Re: Mesa del Sol Montage Unit 4 (Project # PR-2020-003422, Application # SD-2020-00091,  
Hydrology File R16D006A), Comment Response Letter

Enclosed are the responses to the comments provided on the June 17, 2020 DRB hearing.  
Comments and responses are listed below by department.

### Hydrology Section Comments

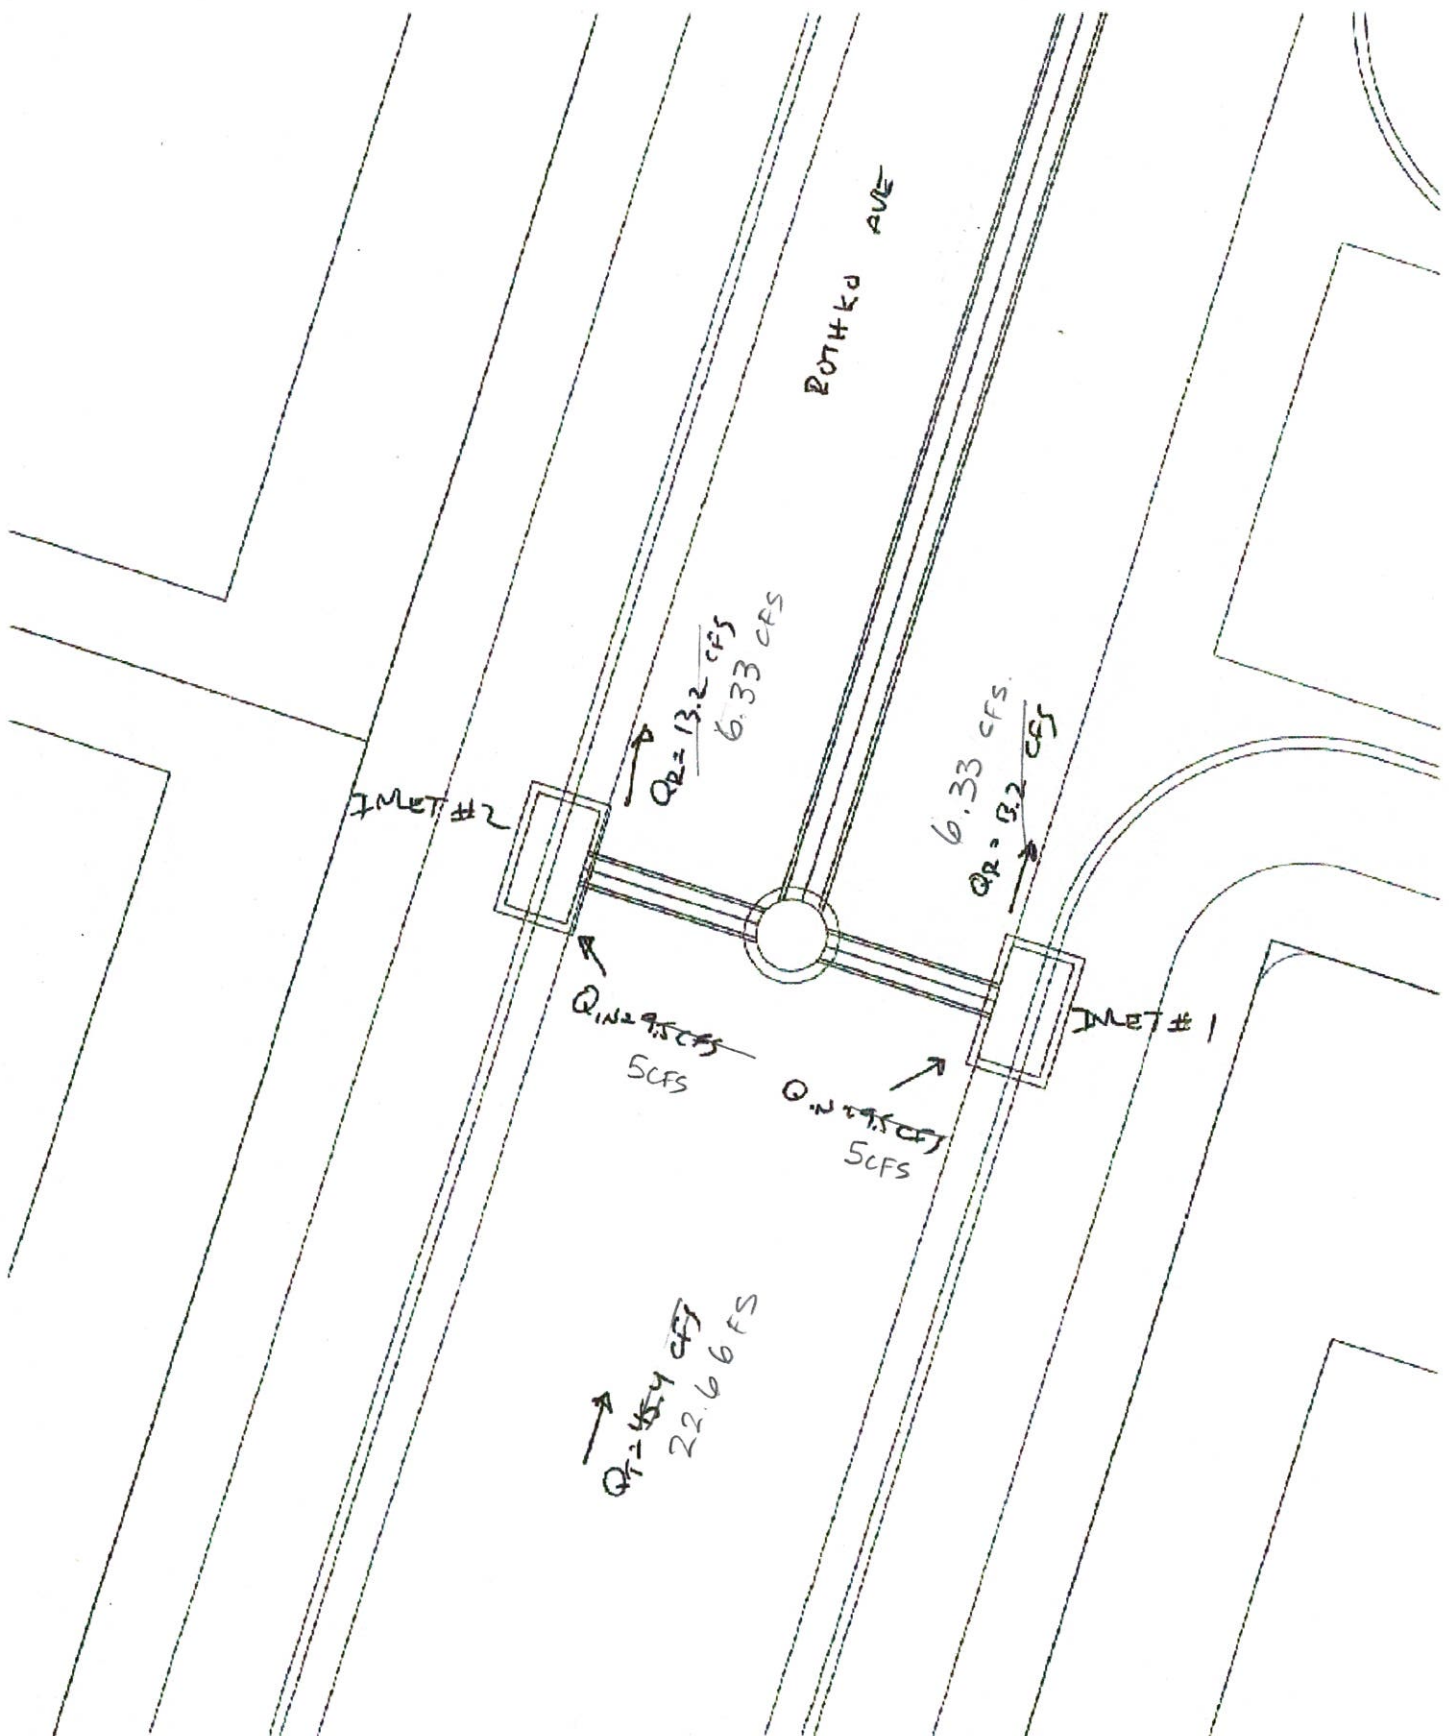
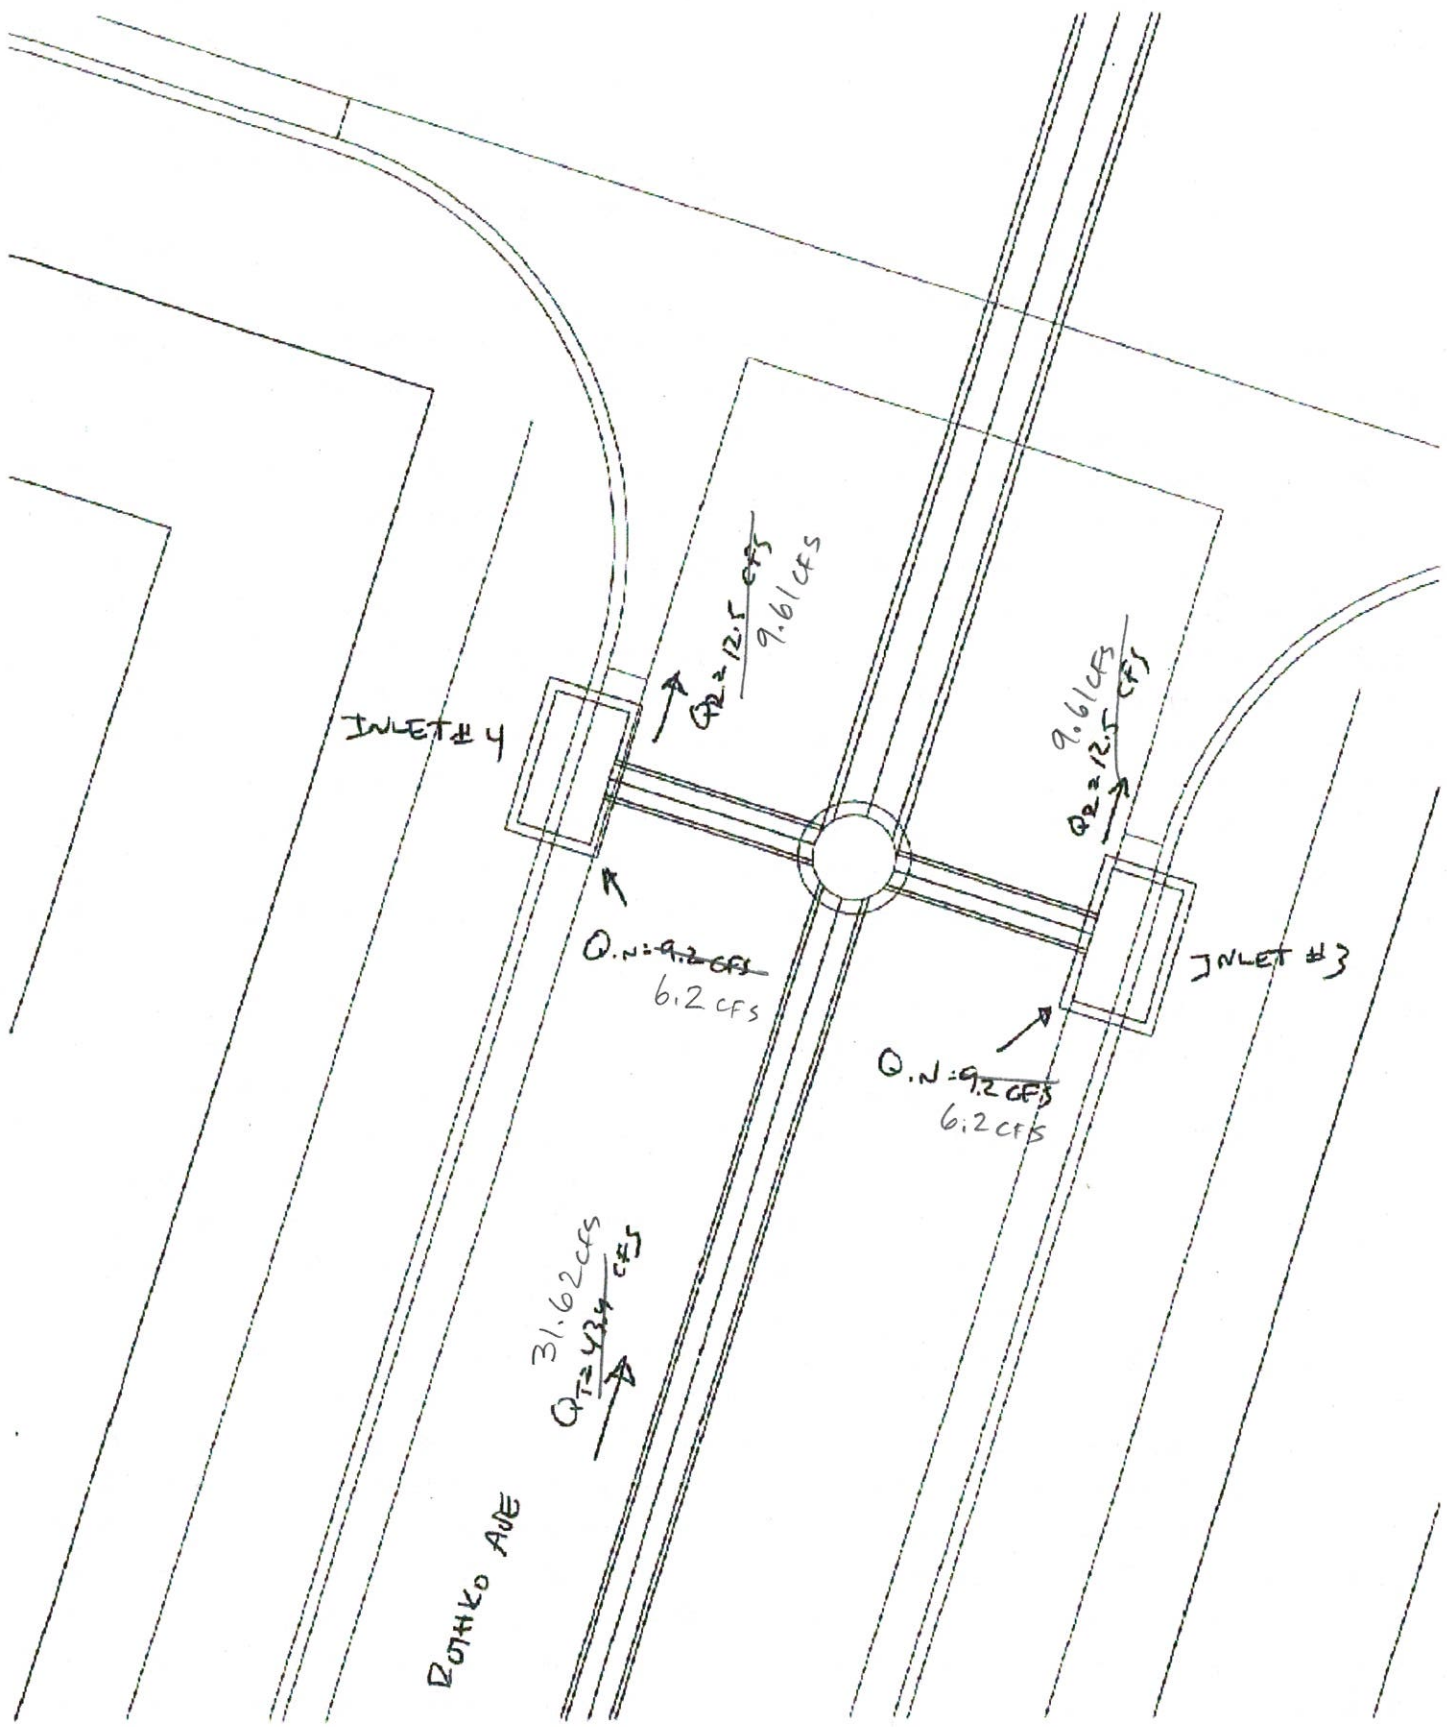
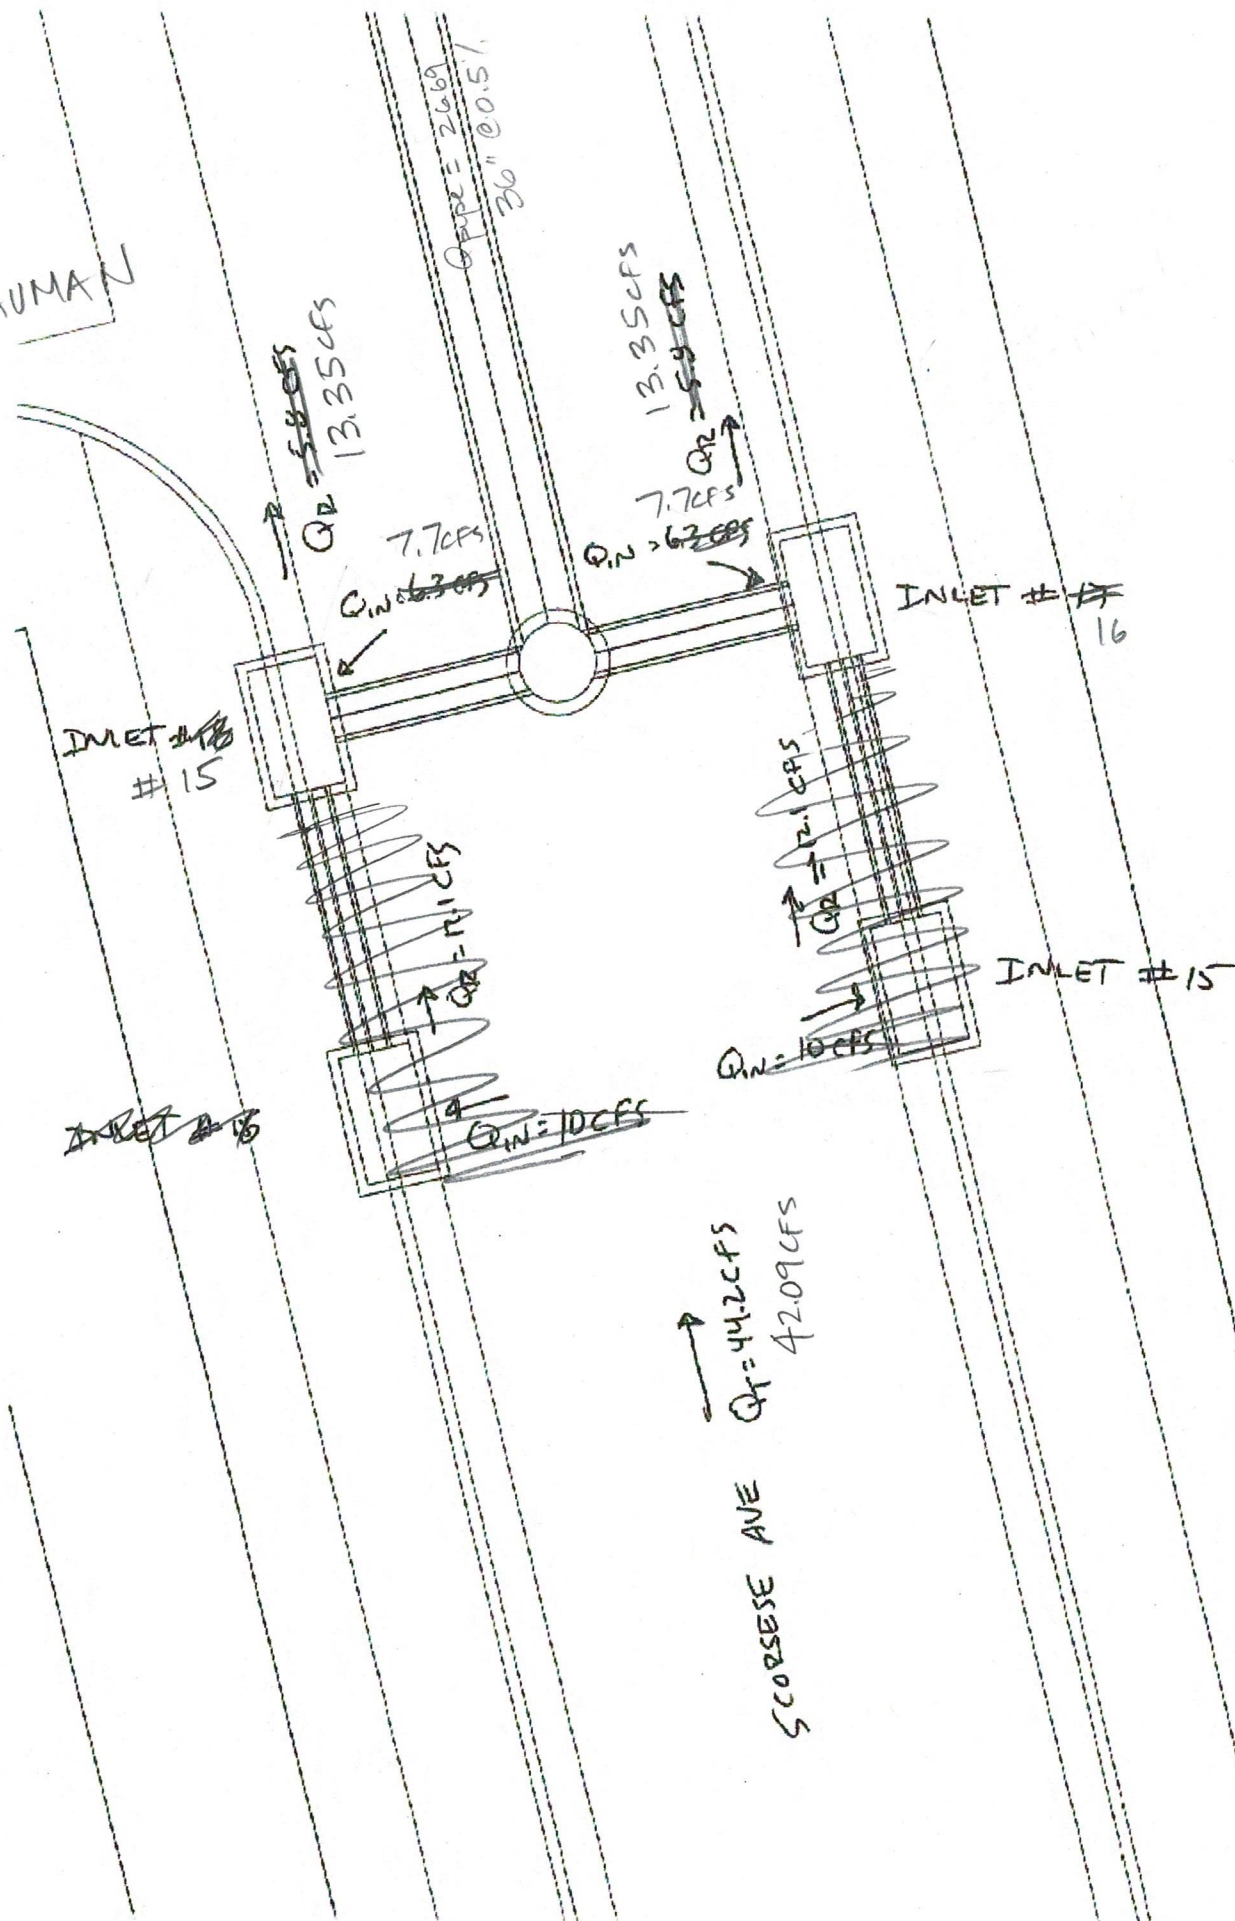
1. An approved grading plan and drainage report is required.  
*Response: A revised grading and drainage is submitted concurrently to this submittal.*
2. In the Amended Drainage Report on pages 30,32 and 36 for inlets on Dekooning and Sagan, please size/type of inlet being analyzed. All previous sections listed this information,  
*Response: Completed. See attached Revised Drainage Report*
